EMAIL: SYMCA.Planning@southyorkshire-ca.gov.uk

DATE: 27 November 2023

LPA Refs: RB2021/1090

Reference: 2021/1090

Proposed illustrative masterplan

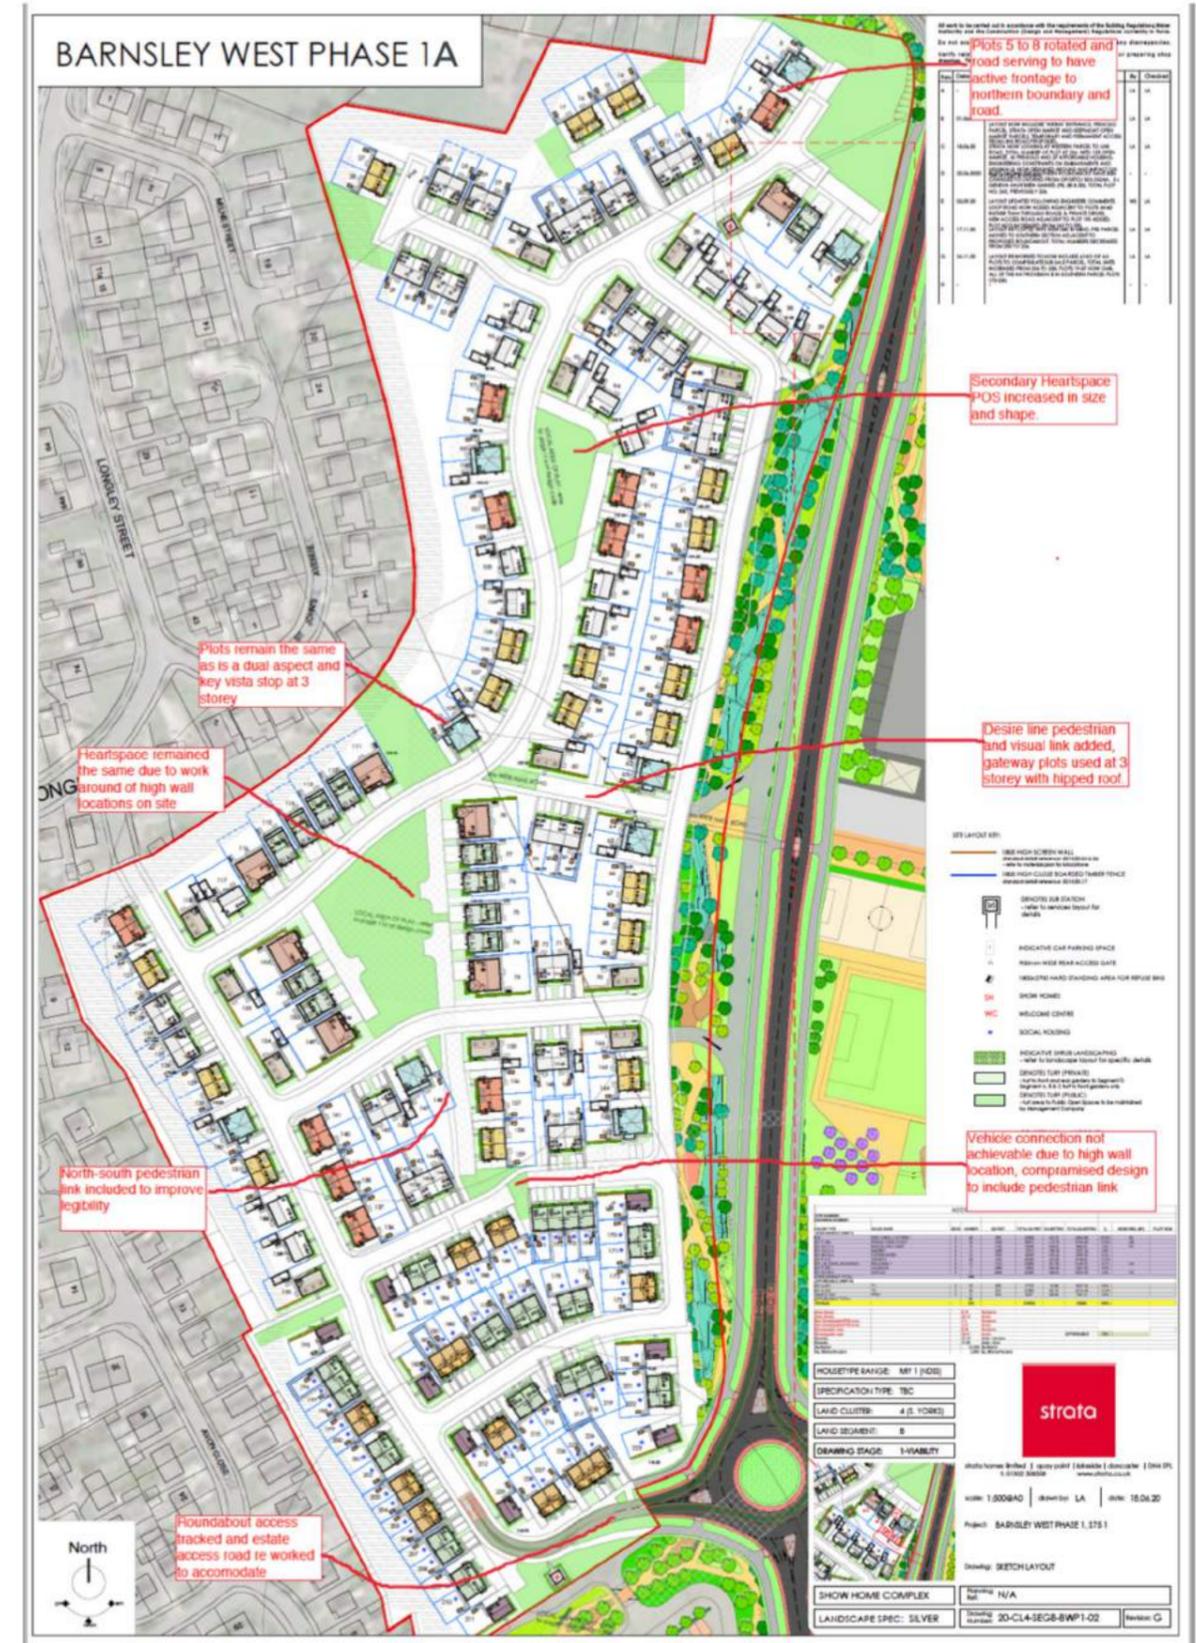
It will be necessary to install bus stops and appropriate bus stop infrastructure along the agreed route of the bus service(s) to support both the proposed residential and employment uses. The current layout is shown on the *Proposed Indicative Site Plan*, drawing no. BWM BBA ZZ XX DR A 1004 rev. P16, dated September 2023. With reference to the current layout we have the following comments to make.

Preferred route: The applicant has indicated that buses will be able to travel around the loop road, and suggests that bus stops are located in that central area. We do not recommend that the bus service are routed via the loop road, and our preference is for a direct service along the link road. Locating a bus stop on the loop road would increase travel times compared with locating a bus stop on the link road. There is a risk of conflict with the residences if a bus stop is retrospectively located on the loop road. And due to the catchment area of the school the bus service is unlikely to see much usage by the primary school pupils – this is corroborated by the applicant's *Transport Assessment* – should any pupils use the bus then this can be safely accommodated by well-designed bus stops on the link road.

Bus stop requirements: There is a need for 2 pairs of bus stops (4 total) to adequately service the proposed residential development. This is in addition to the stops required for the employment use, detailed in our response to application 2021/1089. These bus stops should be located on the link road at indicative locations shown at Annex 1.
